Our Ref: LU/269/18/HH
Your Ref:

Development Vehicular access & hardstanding to front garden.

Location 110 Southfields Road Littlehampton

* NB. INSUFFICIENT AREA TO SHOW
FULL LENGTH OF SPAY. PLEASE SEE 1:1250 LOC'N
PLAN

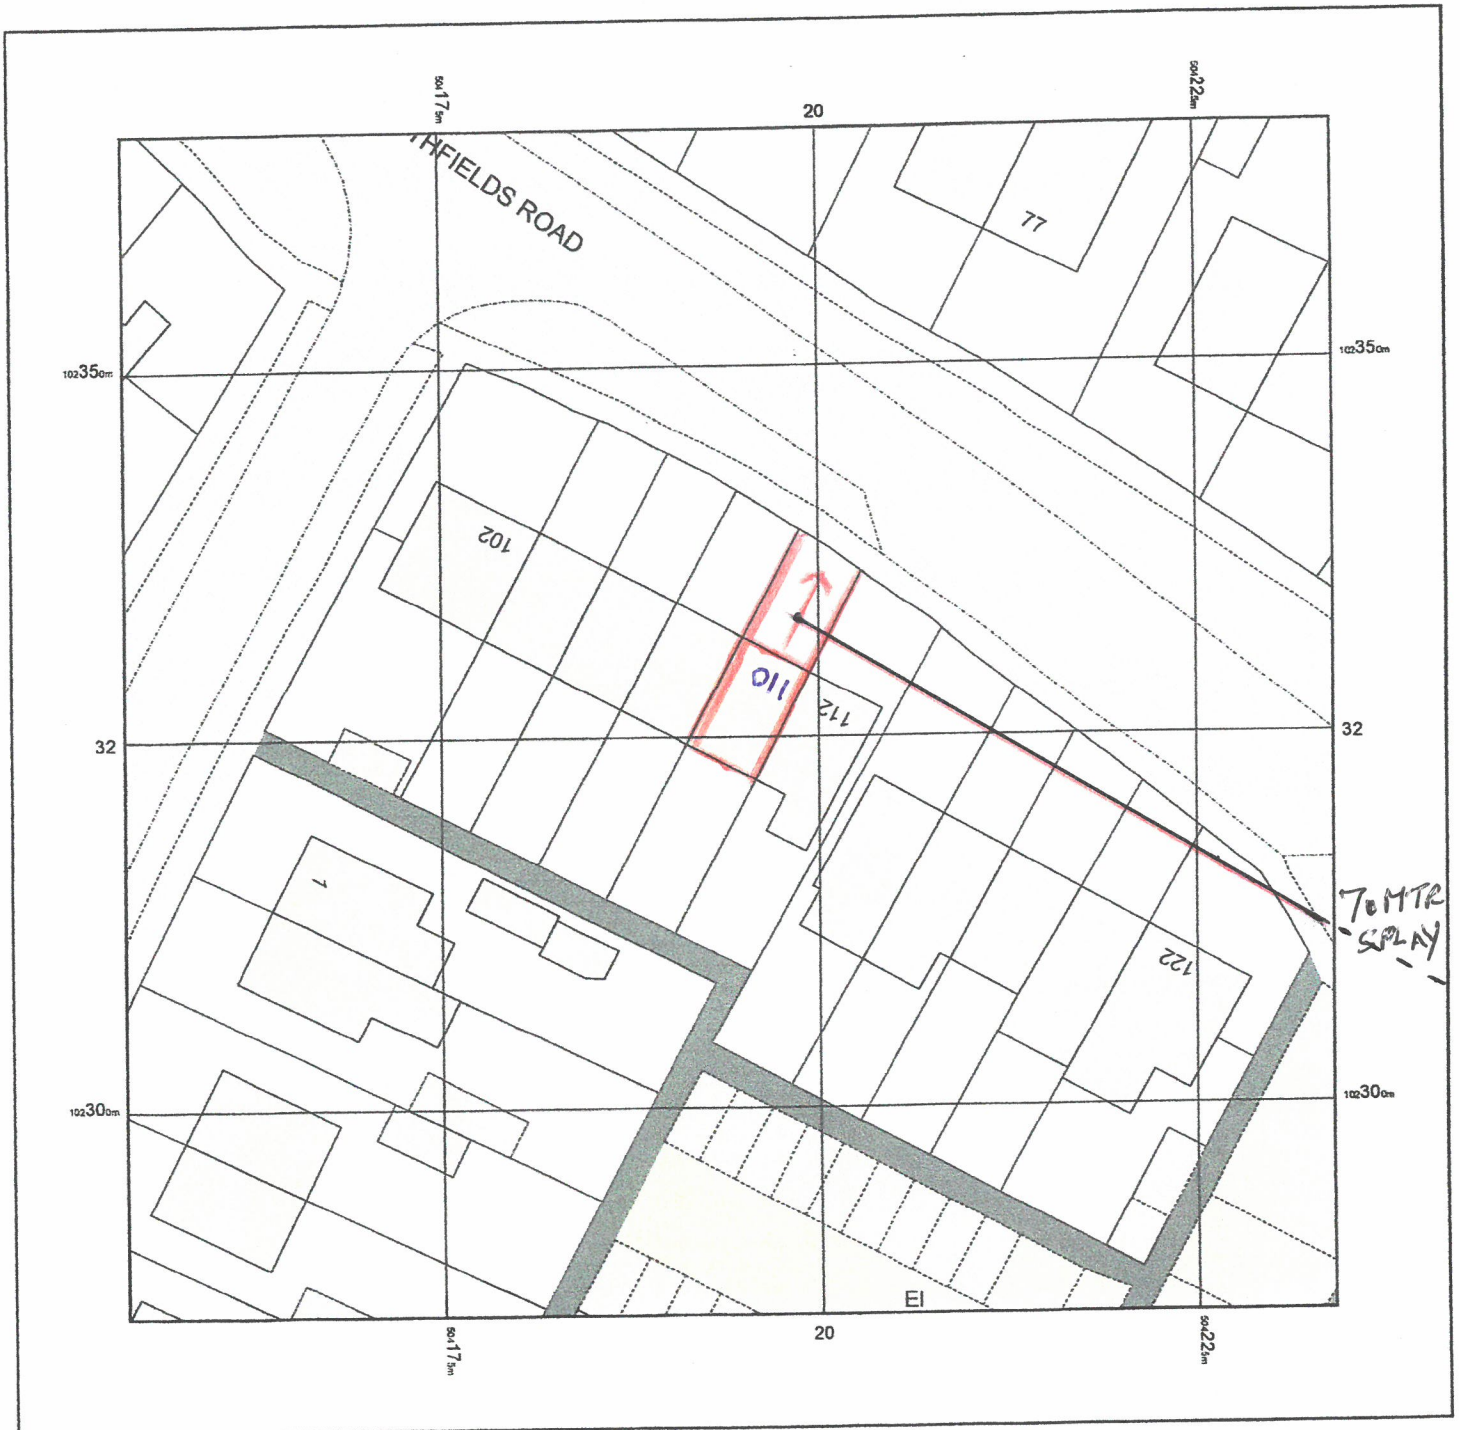
Block Plan Amend

Please clearly highlight the proposed works and provide visibility splays for the new vehicular access.

A visibility splay is formed by measuring to a point 2.4m back from the carriageway in the centre of the driveway or entrance. A line (70m long in the case of a 30mph limit) is then drawn to the right, to a point where it strikes the near-side edge of the carriageway.

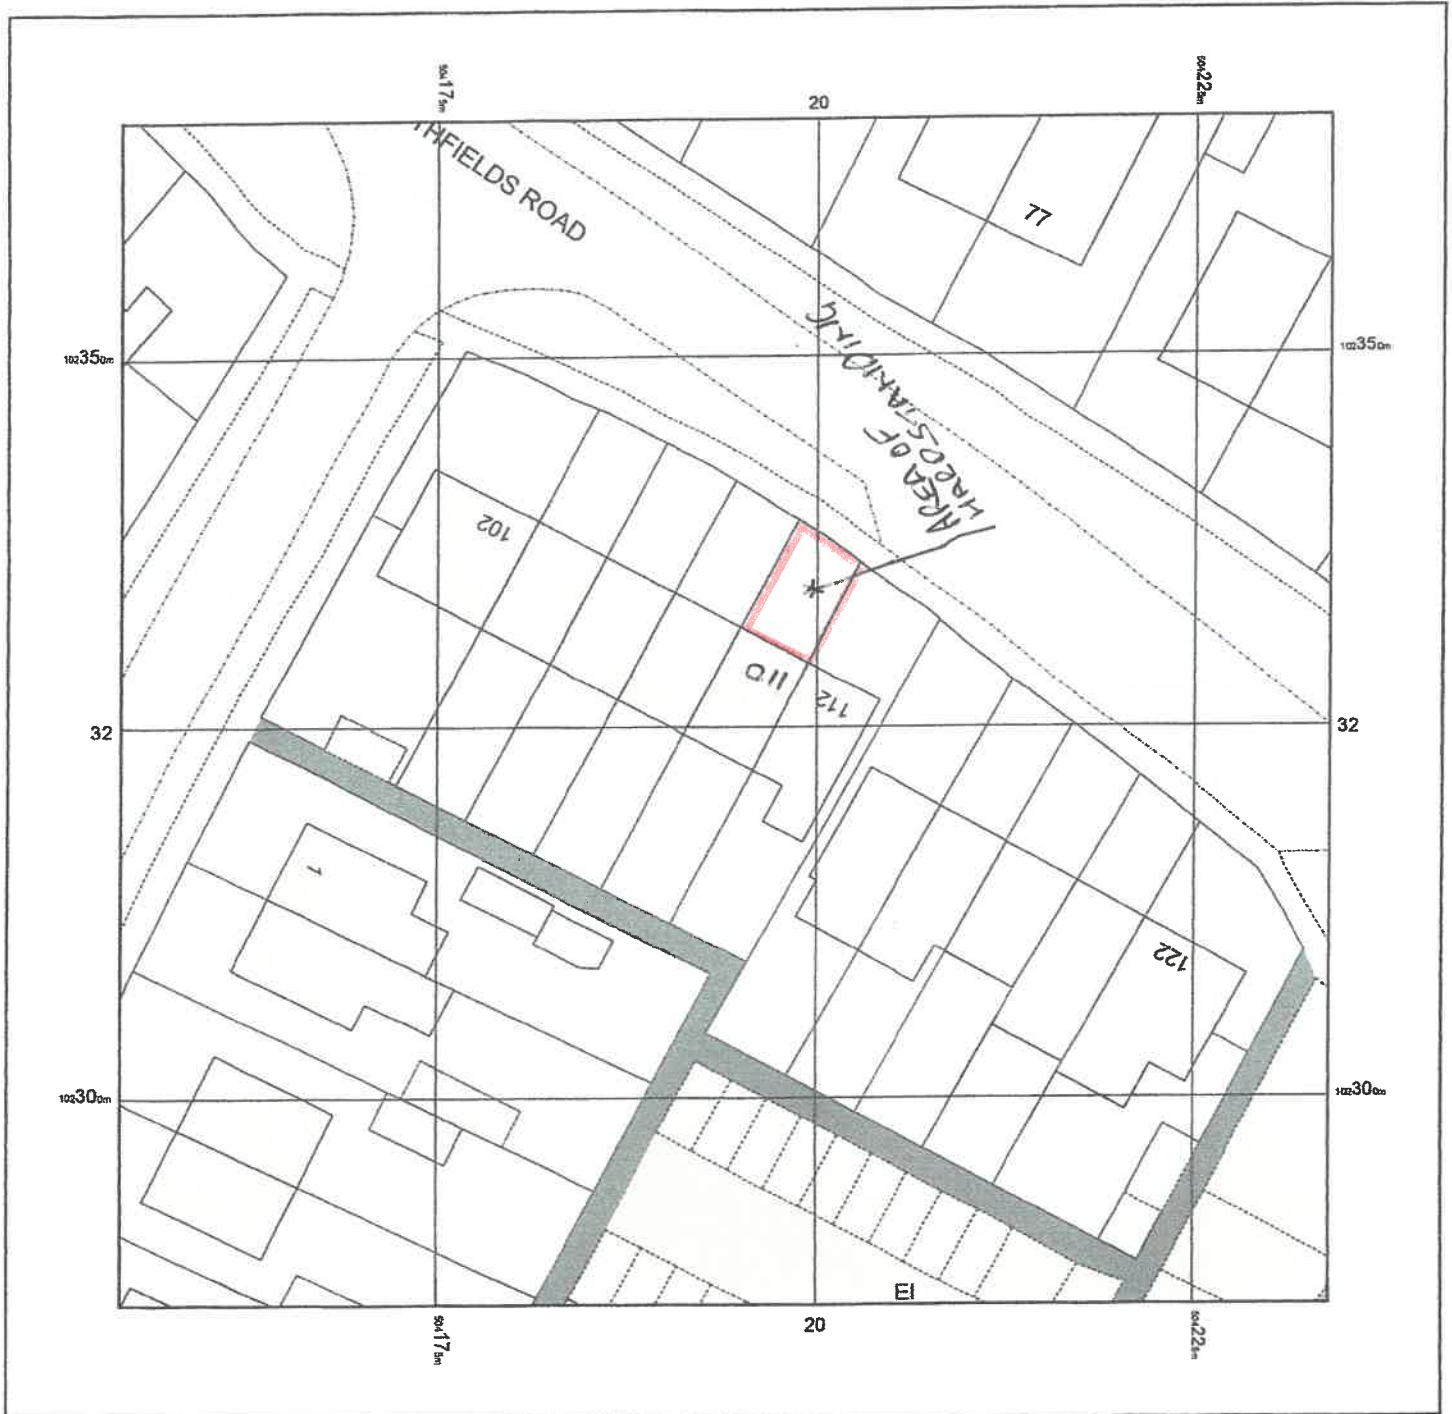
Location Plan Amend

Please red edge the property.
